SUBMISSION OBJECTING TO

Residential flat building with in-fill affordable housing

35-39 Darley Street East, Mona Vale | SSD-113872990

SUBMITTER	John Dorrington	POSITION	Object
CAPACITY	Mona Vale resident	EXHIBITION CLOSES	3 August 2026

PLA-DA-4101

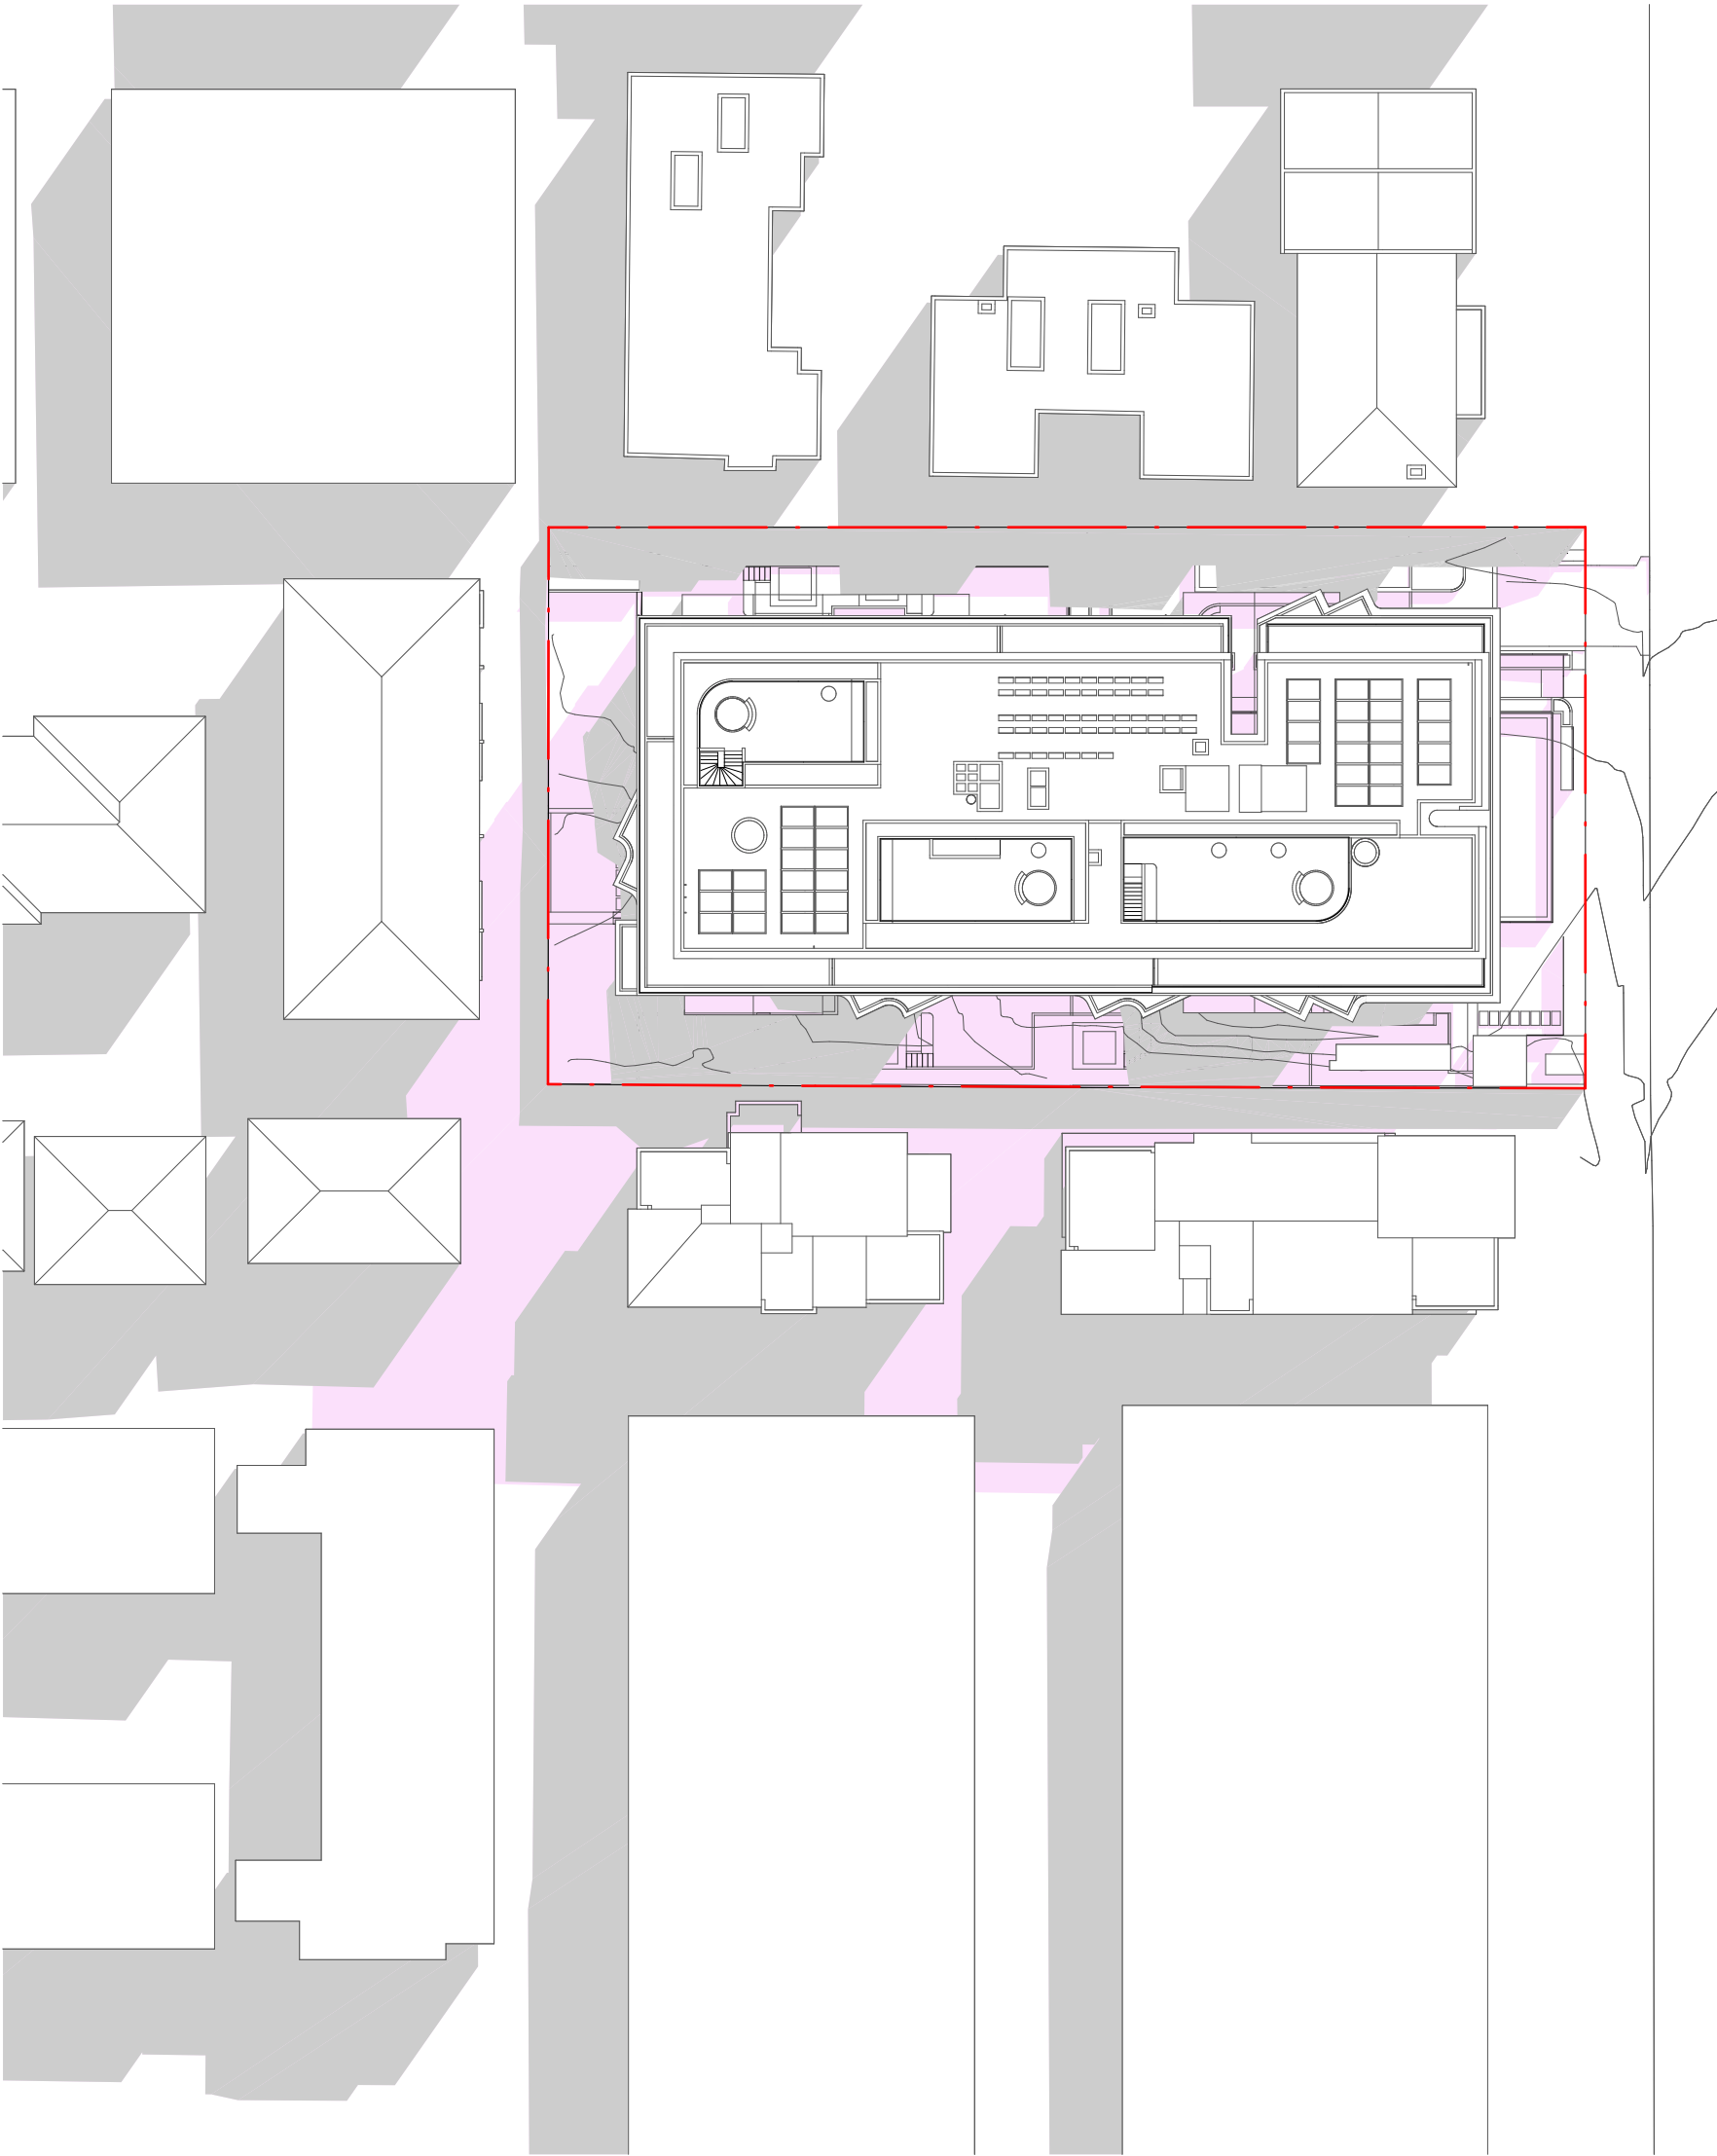
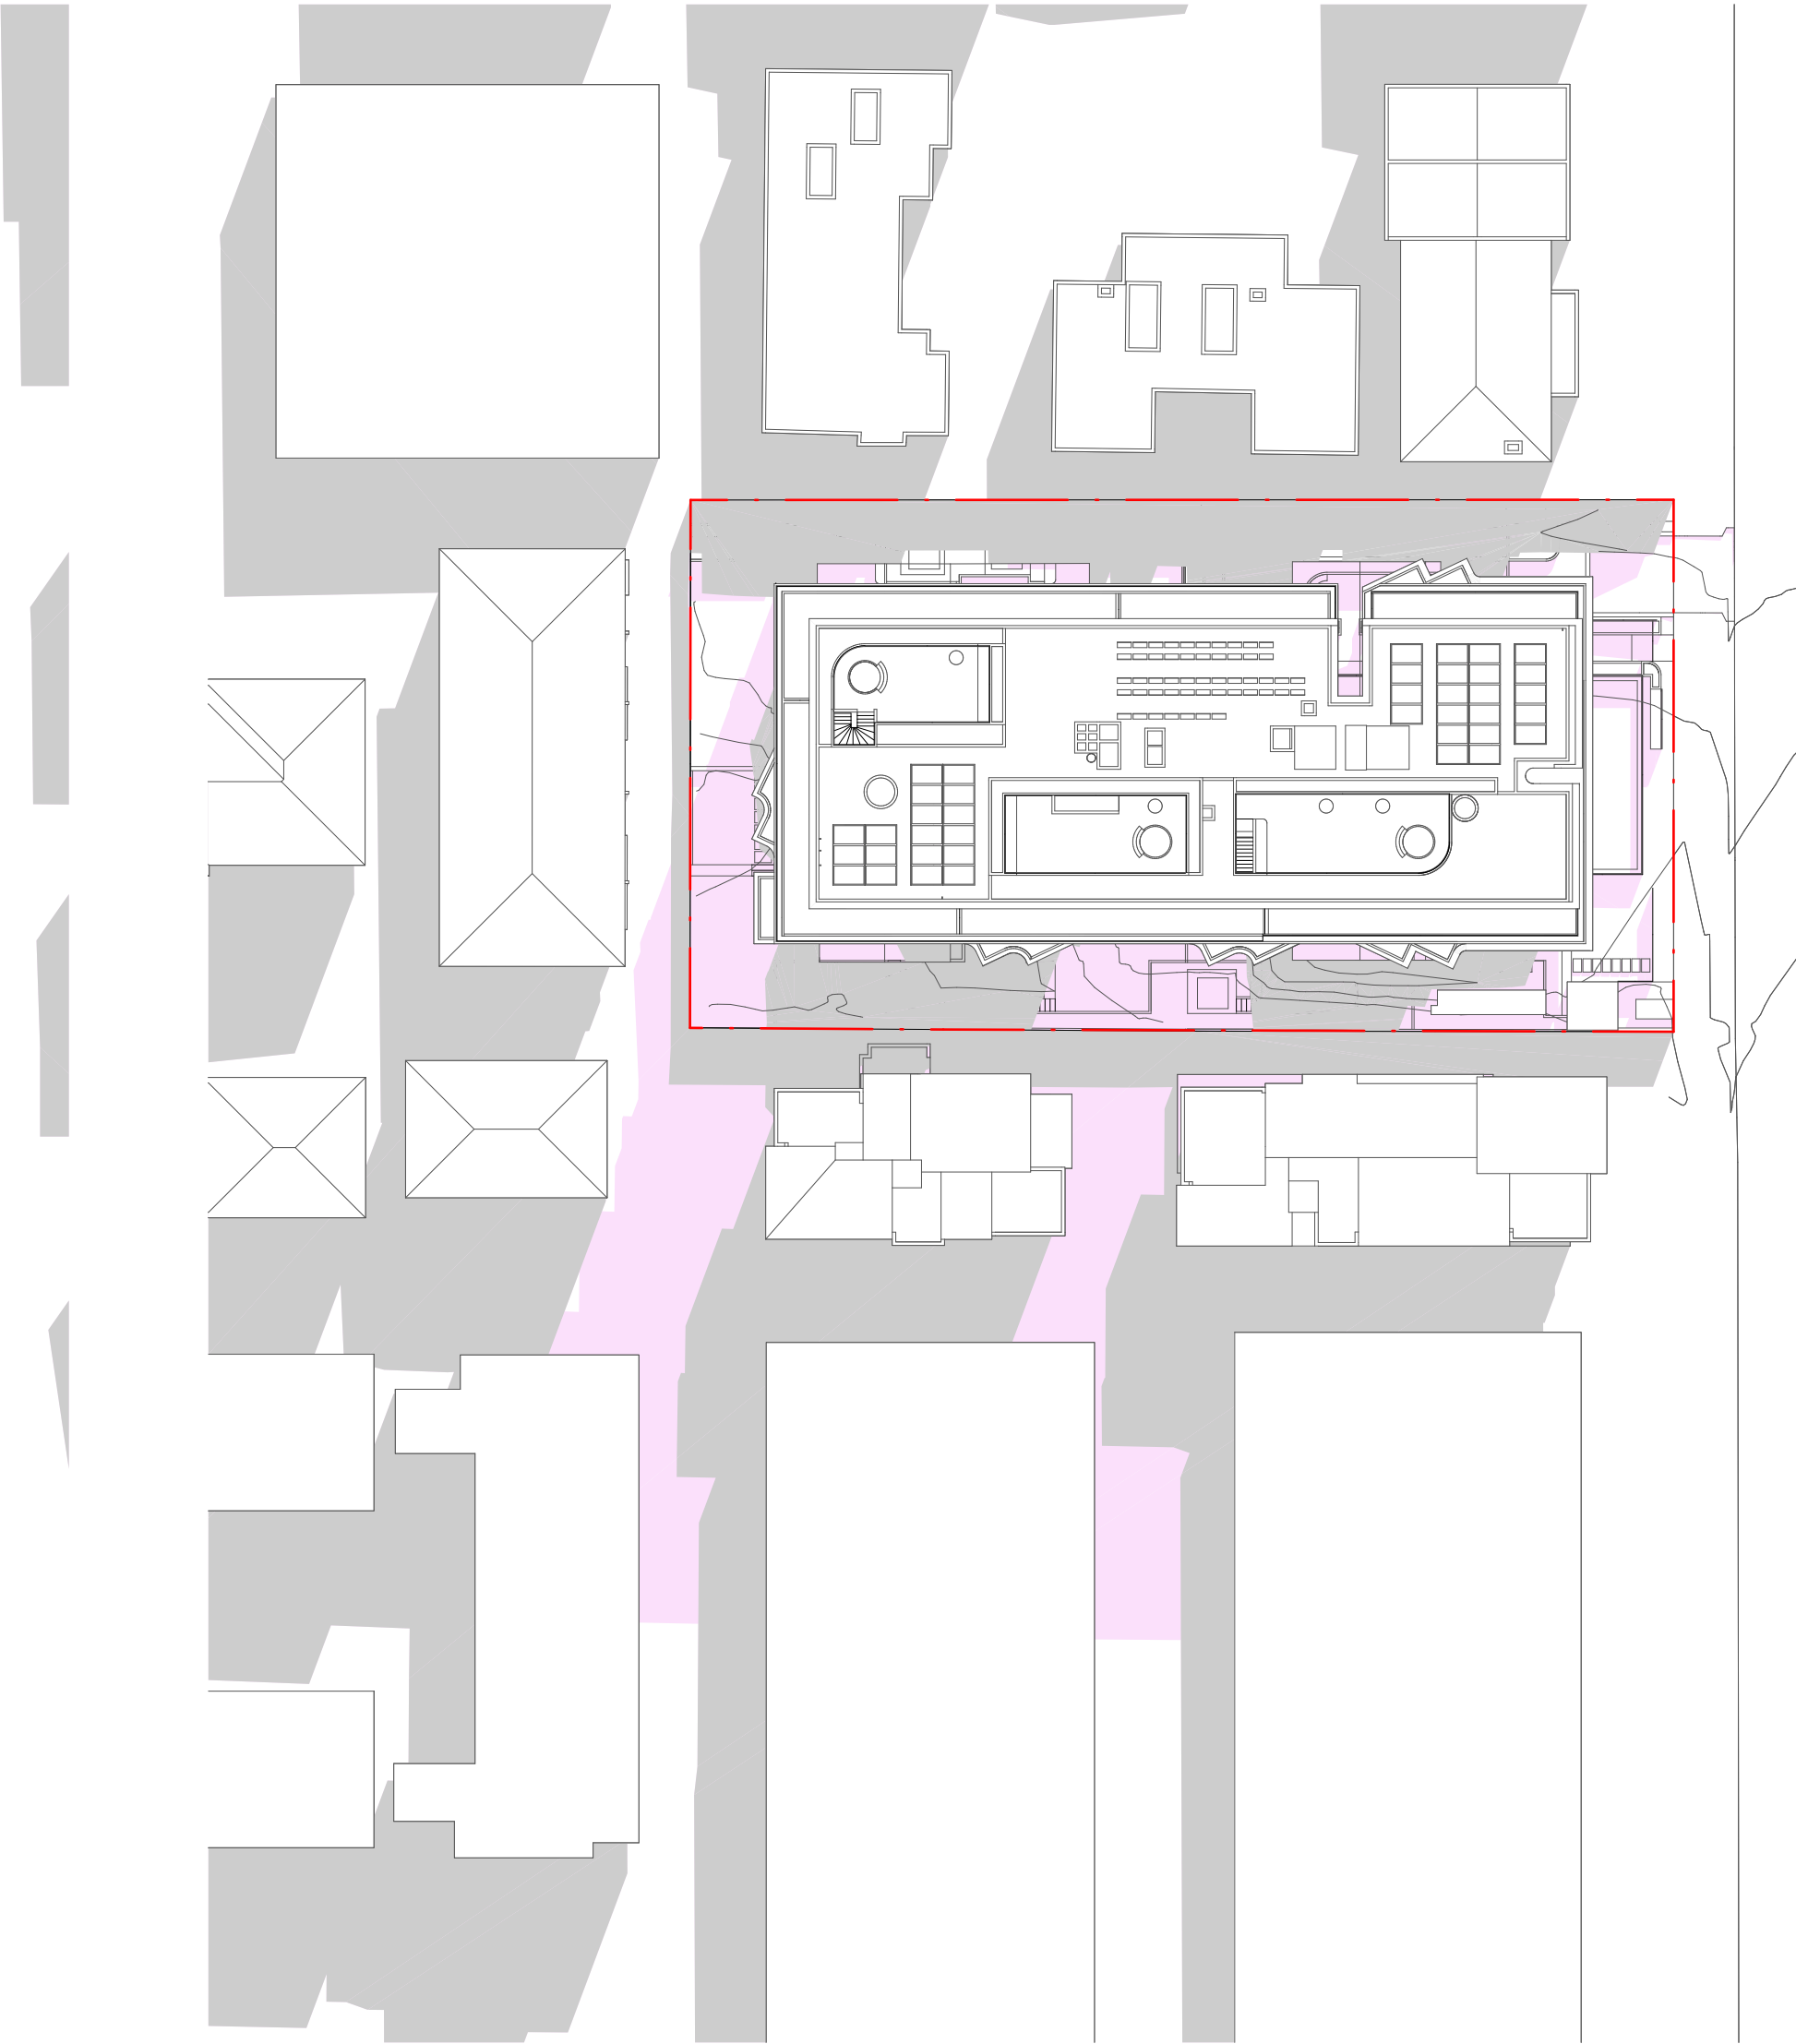
The EIS also concedes that overshadowing is unavoidable and identifies impacts to 28-30 and 32 Golf Avenue, 25-31 and 33 Darley Street East, with additional afternoon shadow extending to 34-36 Golf Avenue. Architectural shadow drawings PLA-DA-4100 and PLA-DA-4101 show new shadow extending across neighbouring land from 9 am through 3 pm on 21 June. The drawings do not support any suggestion of 'no impact'.

Before determination, the Department should require an independent peer review of the shadow model, quantified results for every affected dwelling and private open space, and a comparative analysis demonstrating the reduction achieved by deleting the upper two levels. Additional shadow should not be dismissed merely because a bonus exists.
